## *Rezoning Petition Review*

**Date of Review:** August 27, 2020 (***Revised September 25, 2020***)

**Rezoning Petition #:** 20-99

**Location of Property:** Approximately 20.88 acres located along the southeast side of Mallard Creek Rd and north of Morris Estate Dr.

REVISIONS:						REV REVISION DESCRIPTION DATE: CHANGED CHEC
DATE:	DESIGN BY:	DRAWN BY:	CHECKED BY:	APPROVED BY:		
	Mallard Creek Townhomes		Charlotte, NC		Bezoning Plan	
): 651032401			09/14/20

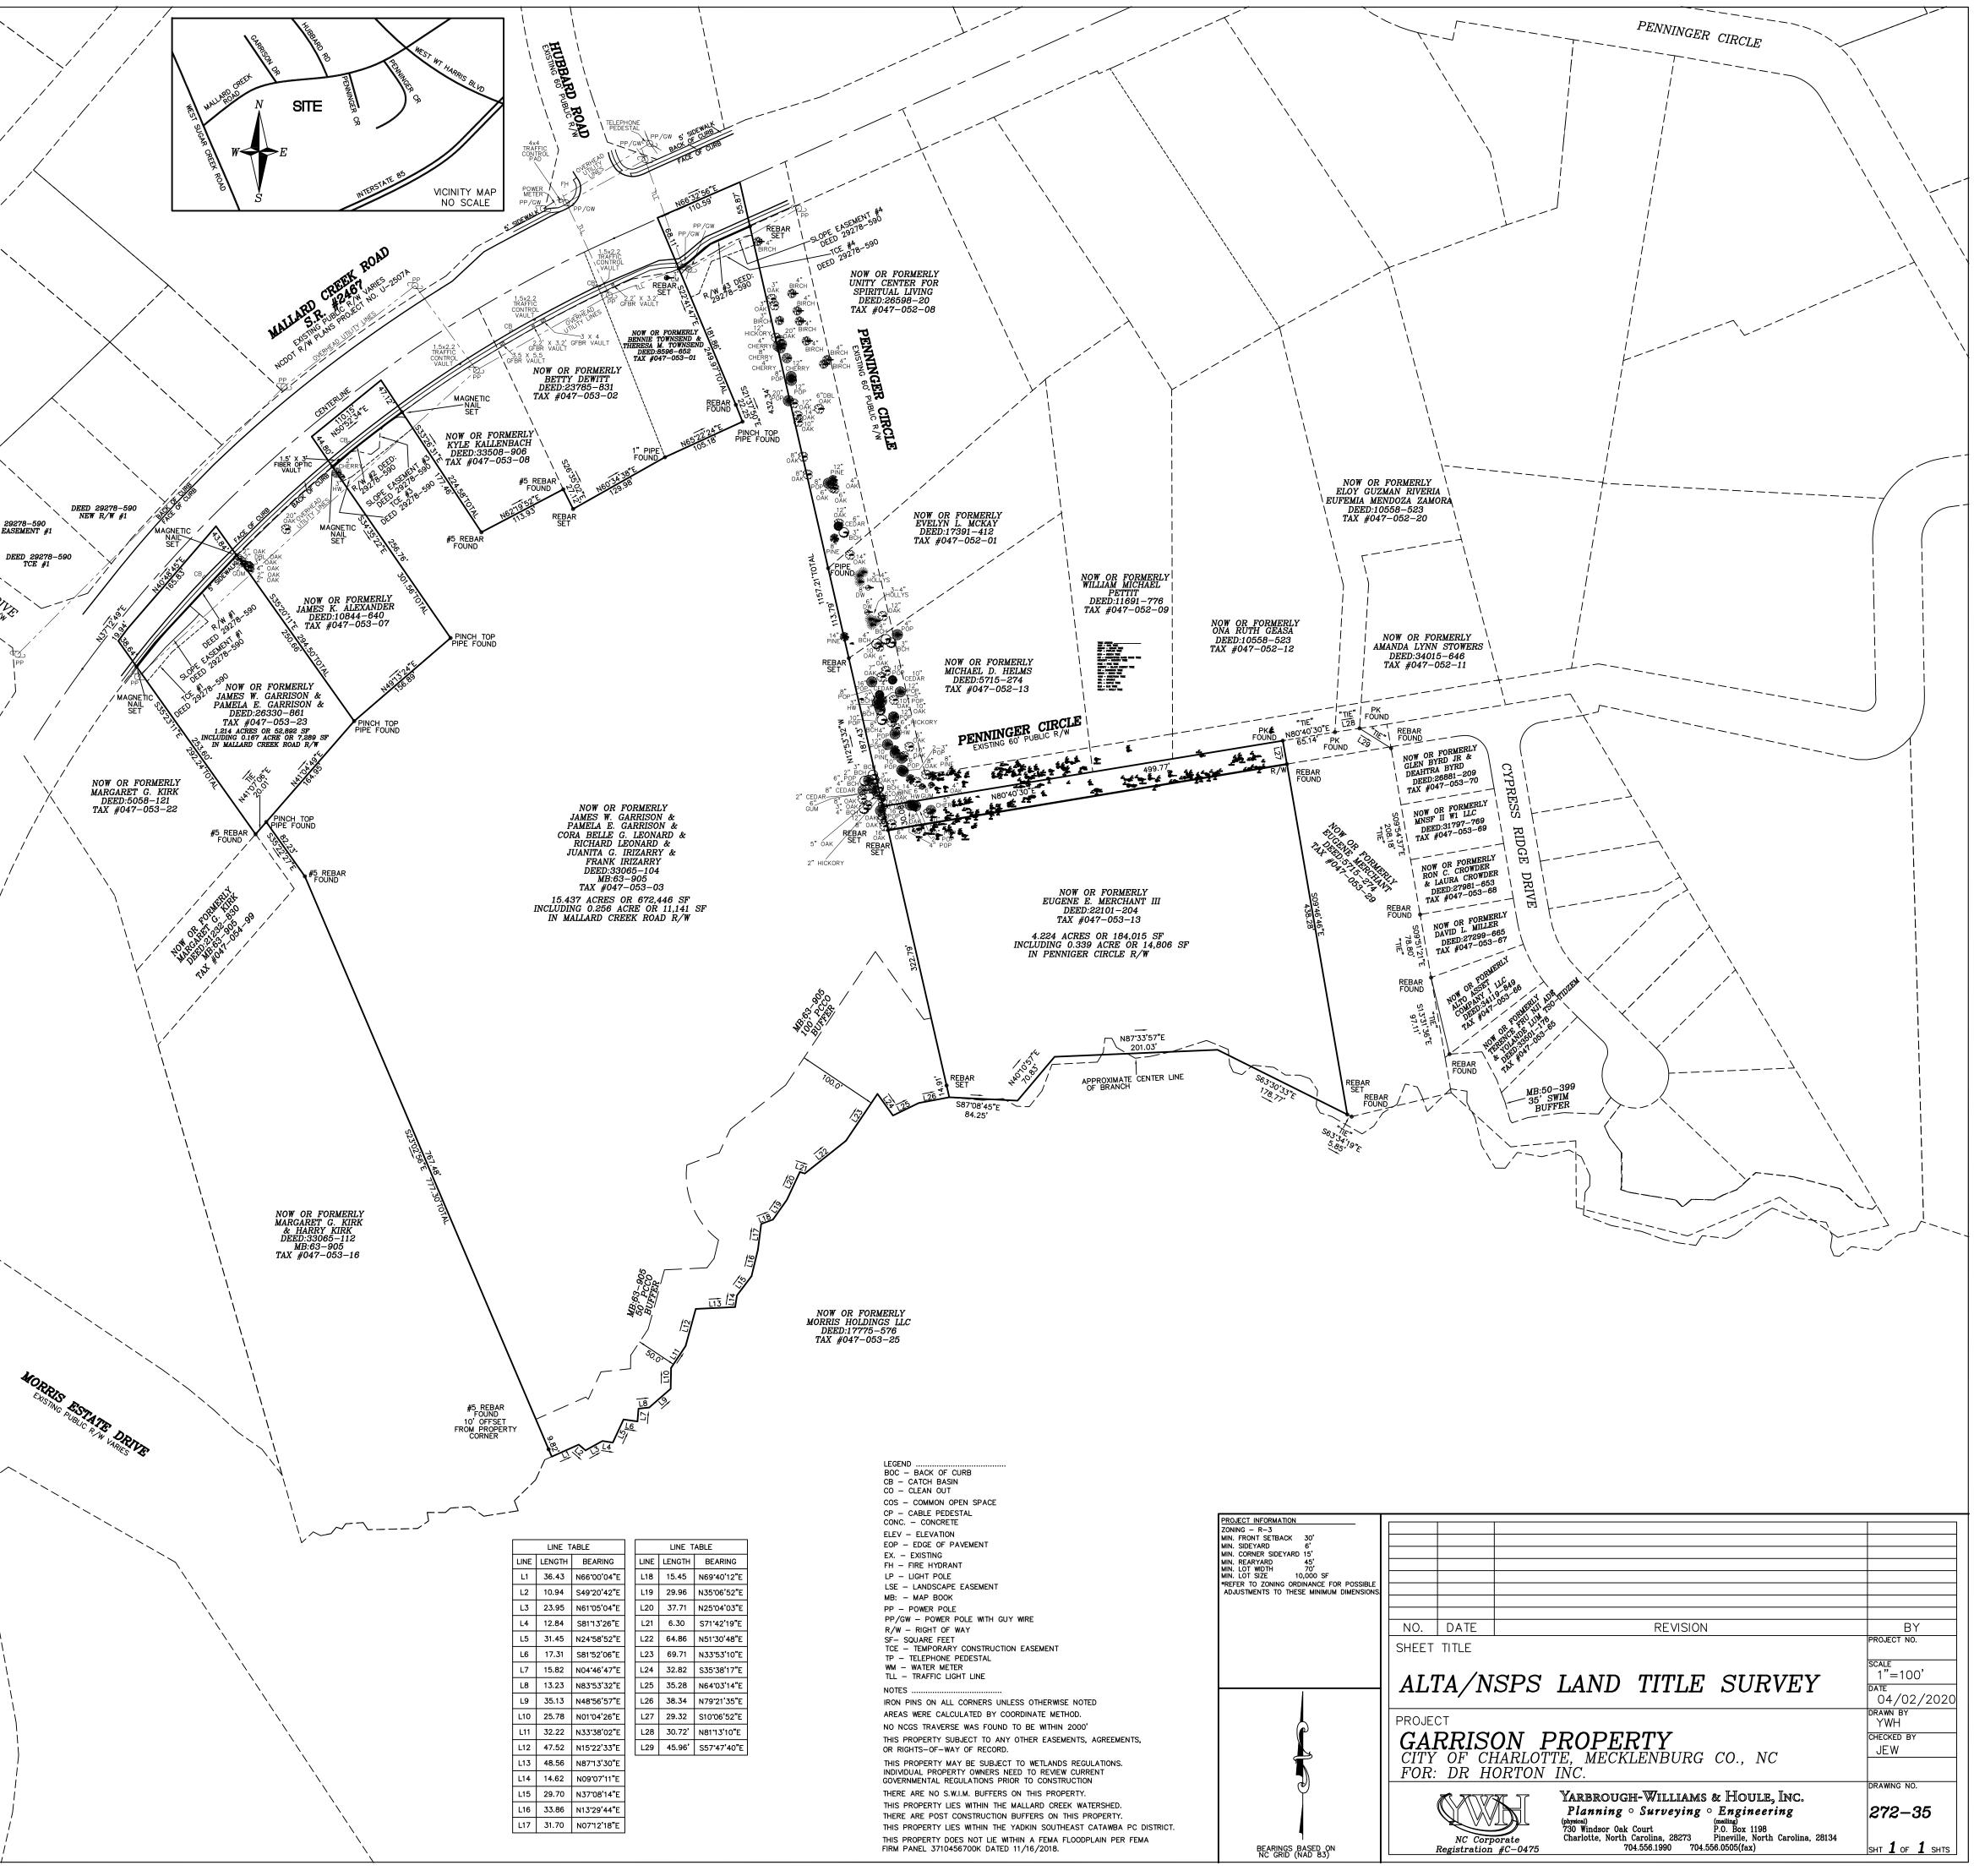
**Concerning Storm Water:** Please revise the label reading *50' Water Quality Buffer* and *100' Steam Buffer* to read *50-ft Undisturbed PCSO Buffer* and *100-ft Undisturbed PCSO Buffer*.

***Due to revisions (9/25/20):*** No additional recommendations are needed at this time.
